From: Laura Gibbons <Laura.Gibbons@arun.gov.uk>
Sent: 01 June 2021 15:36
To: Planning.Responses <Planning.Responses@arun.gov.uk>
Cc: Michael Eastham <Michael.Eastham@arun.gov.uk>
Subject: RE: Planning Consultation on: A/85/21/DOC

Thank you for consulting us on this discharge of conditions application, we have the following comments.

Application No: A/85/21/DOC
Registered: 30th April 2021
Site Address: Land at Dappers Lane Angmering Littlehampton
Description of Works: Approval of details reserved by condition imposed under ref A/76/20/PL relating to Condition Nos 17 - existing & proposed ground levels, proposed finished floor levels, levels of any paths, drives, garages & parking areas & the proposed completed height of development & any retaining walls, 18 - surface water drainage, 19 - maintenance & management of surface water drainage, 21 - discharge flows to watercourses and 22 foul drainage system.

Highway and Drainage Longitudinal Sections

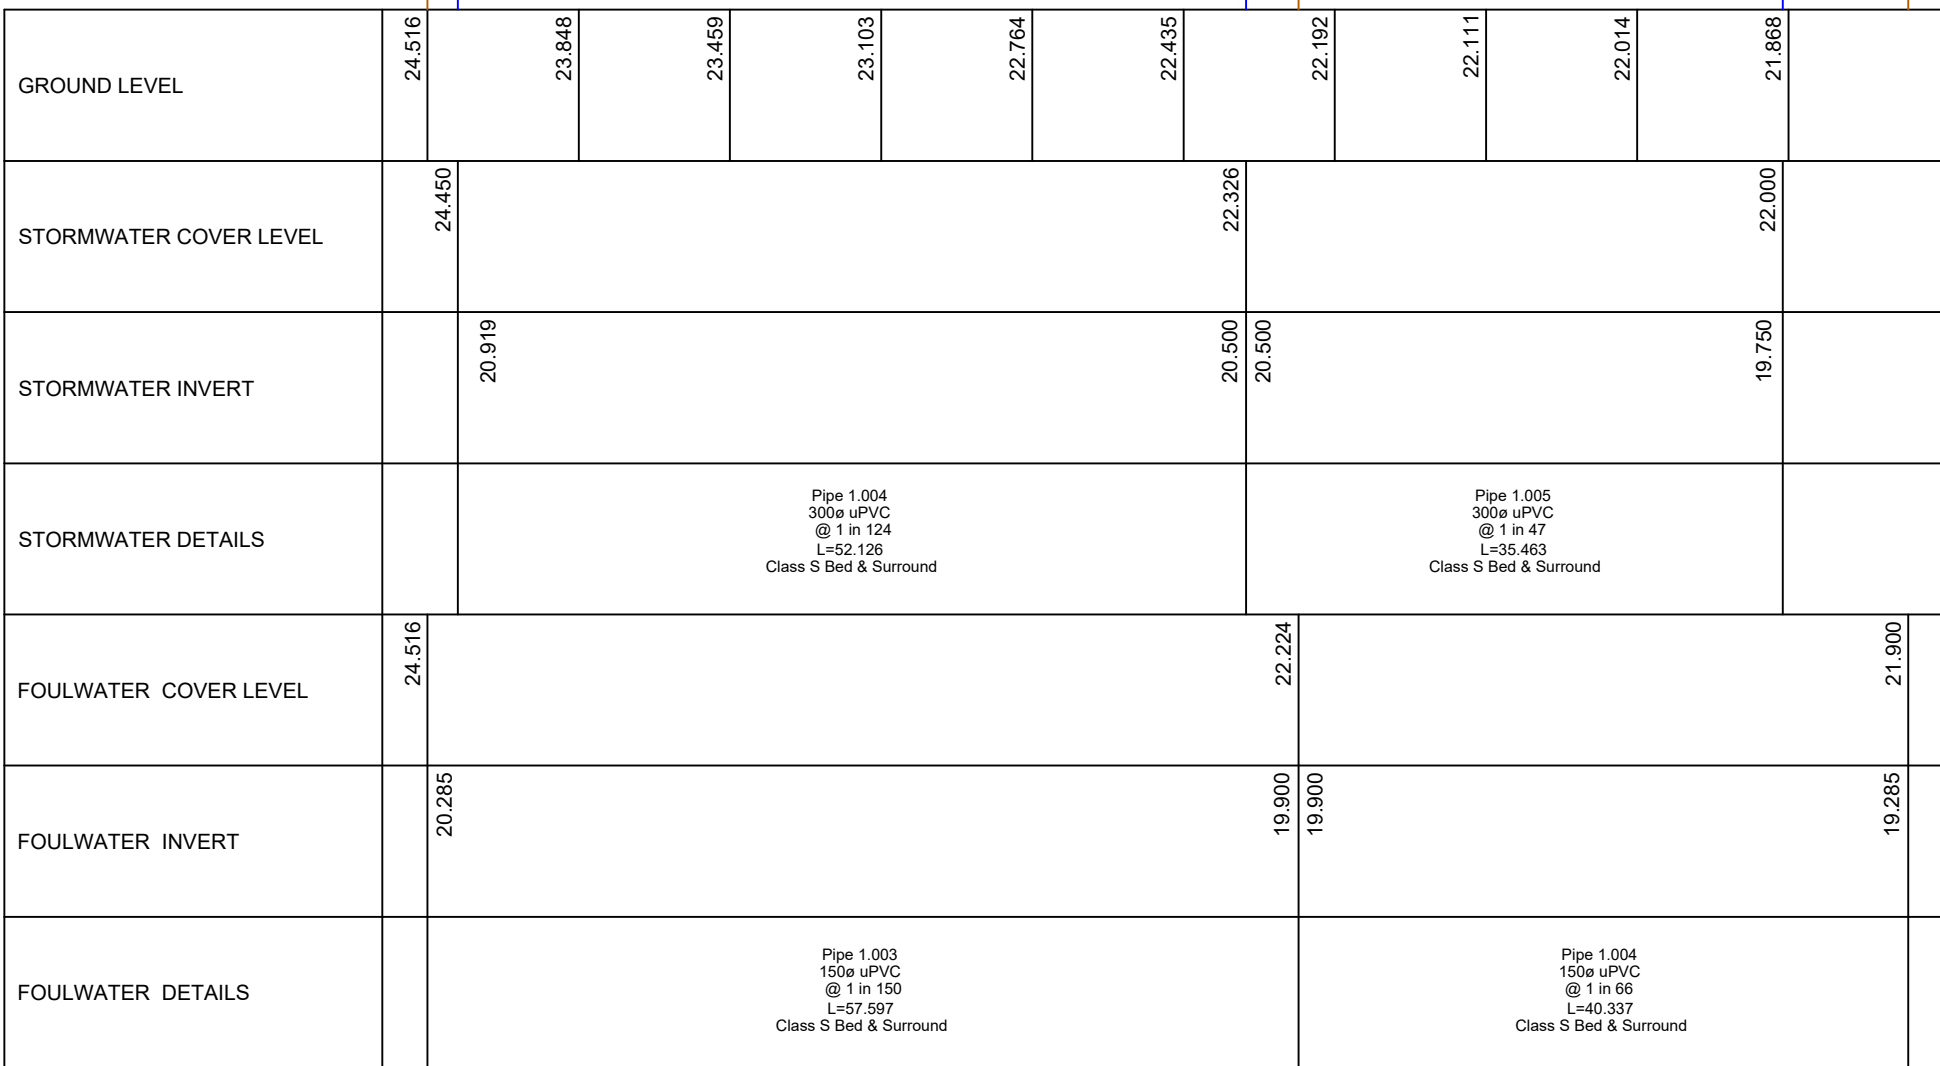
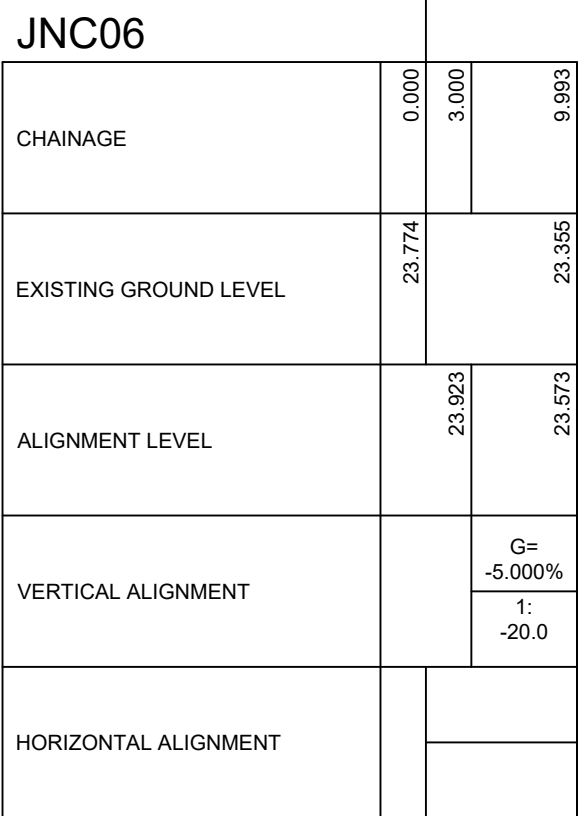
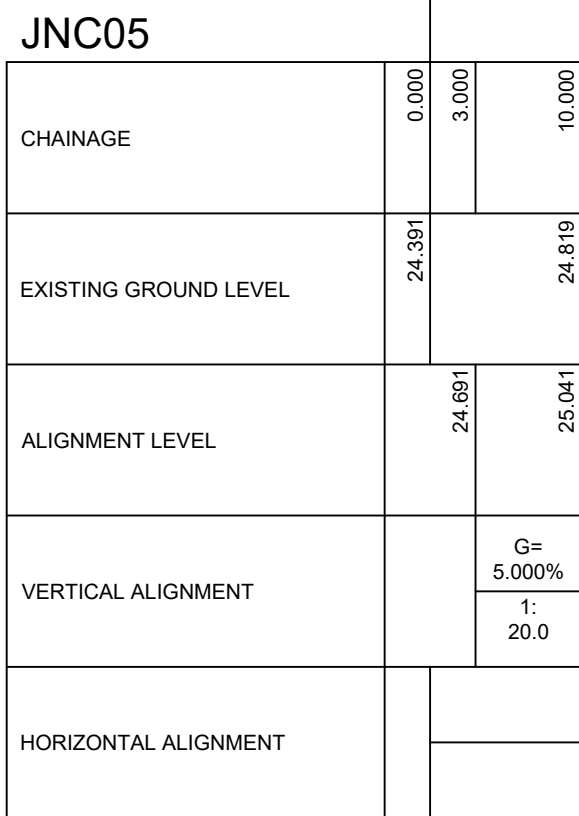
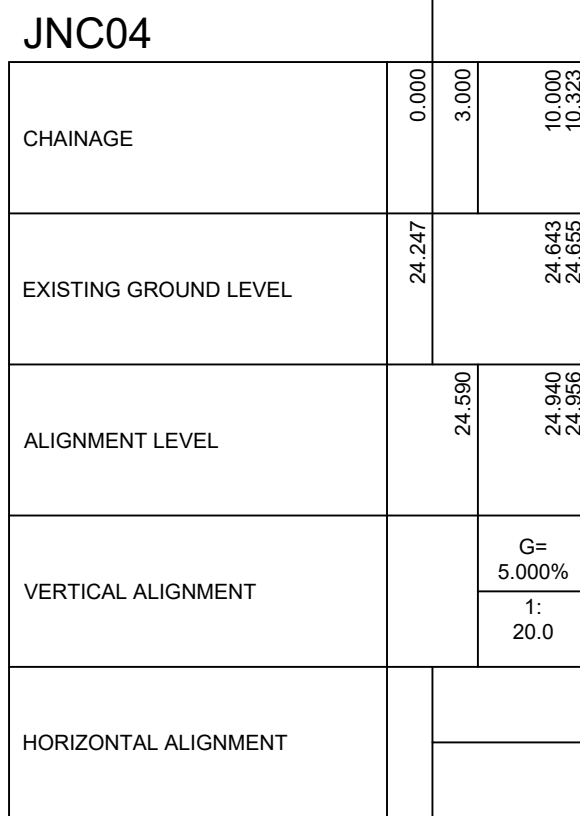
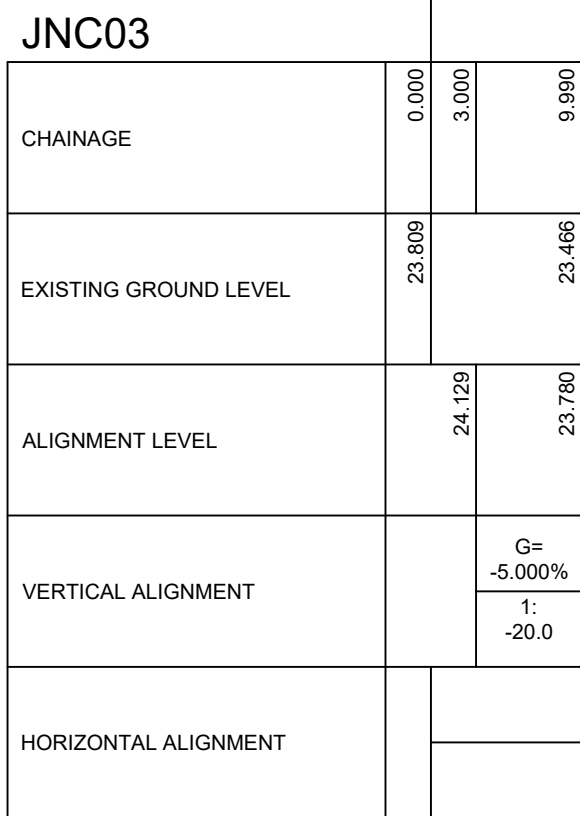
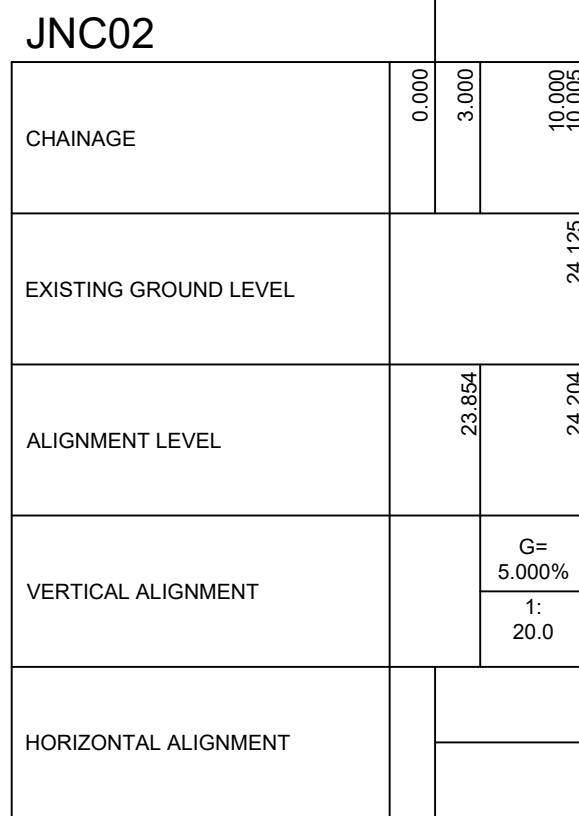
We note that significant land raising of circa 1m is proposed. We do not support this and will need to carefully consider the impacts of any such proposals on adjacent sites in terms of surface water runoff and groundwater levels.

Attenuation Pond 1 Detail

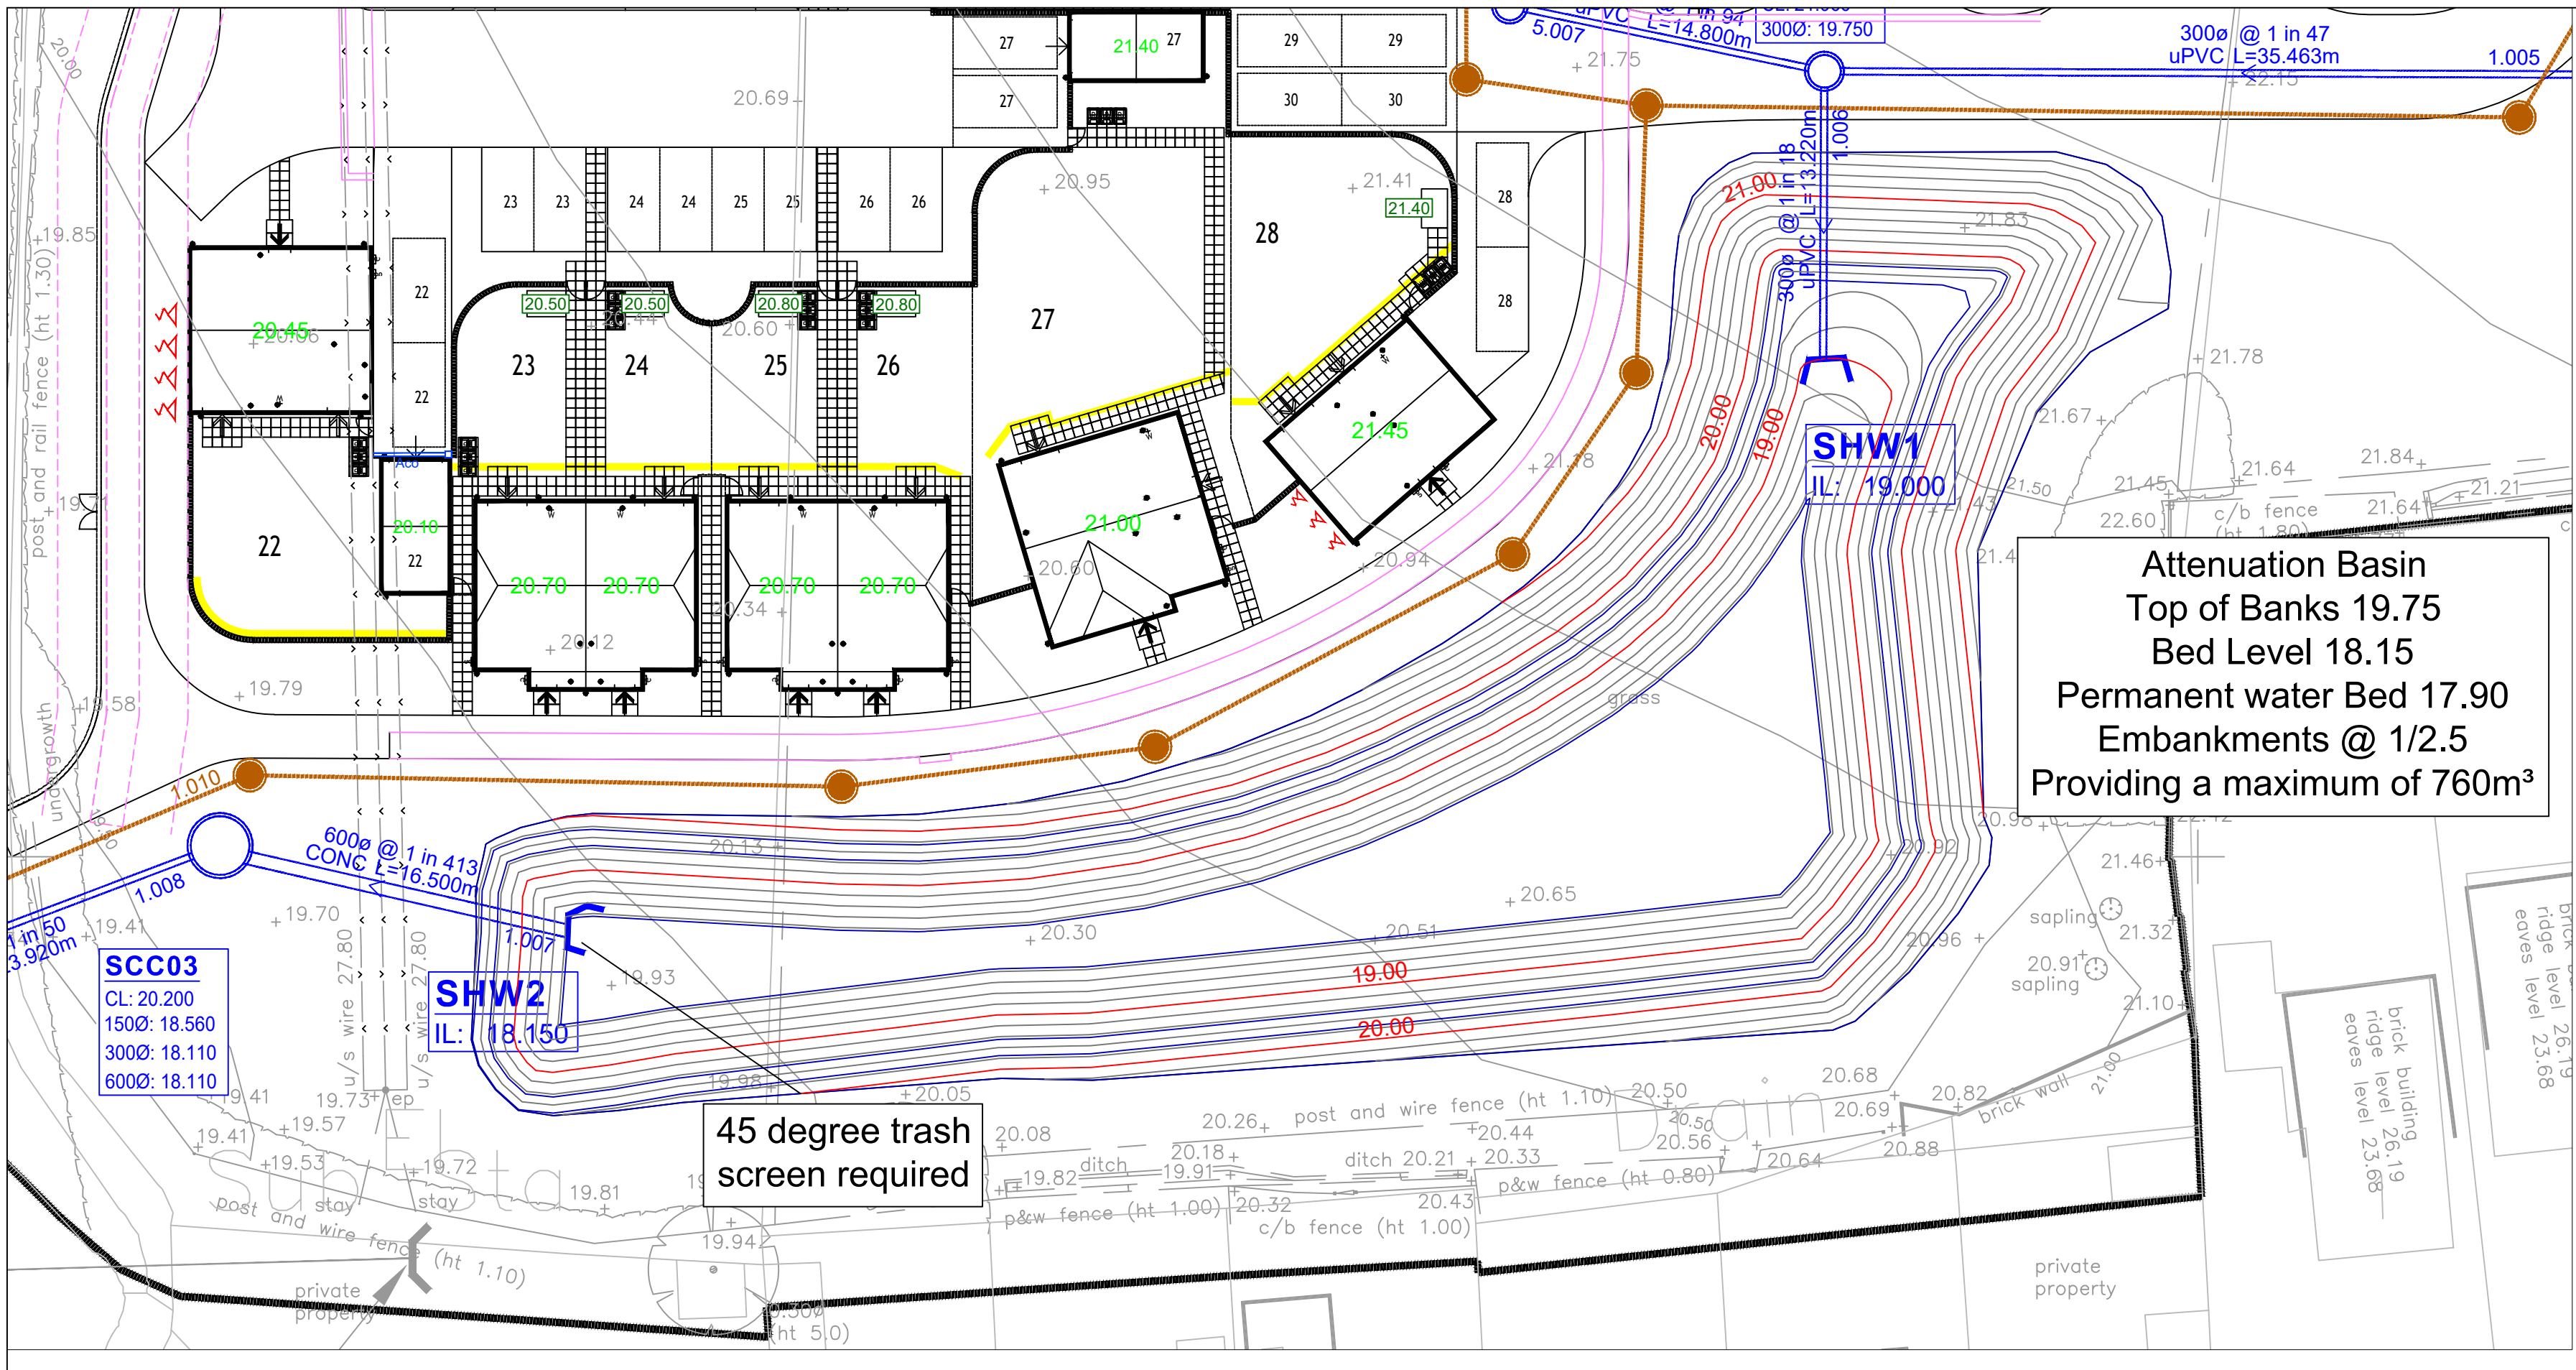
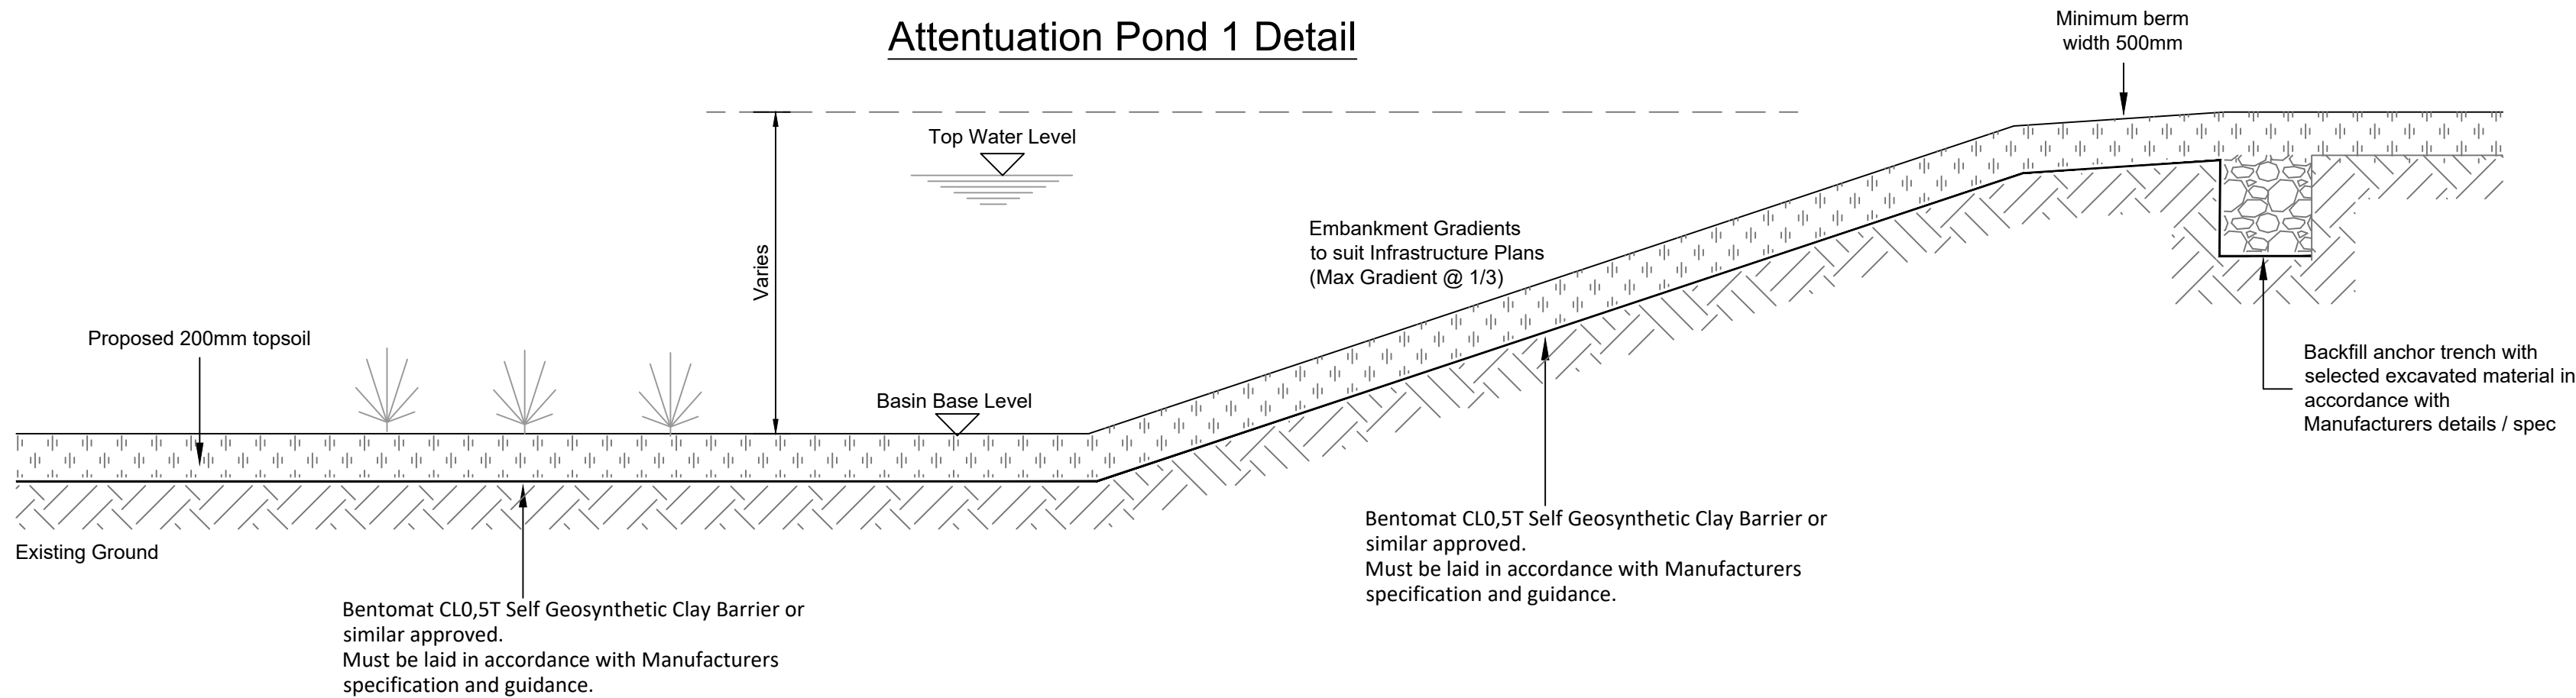
4. Attenuation basins must have maximum side slopes of 1 in 3 and have a clear 3m buffer around them.
5. A review of construction details will be completed once more information has been supplied.
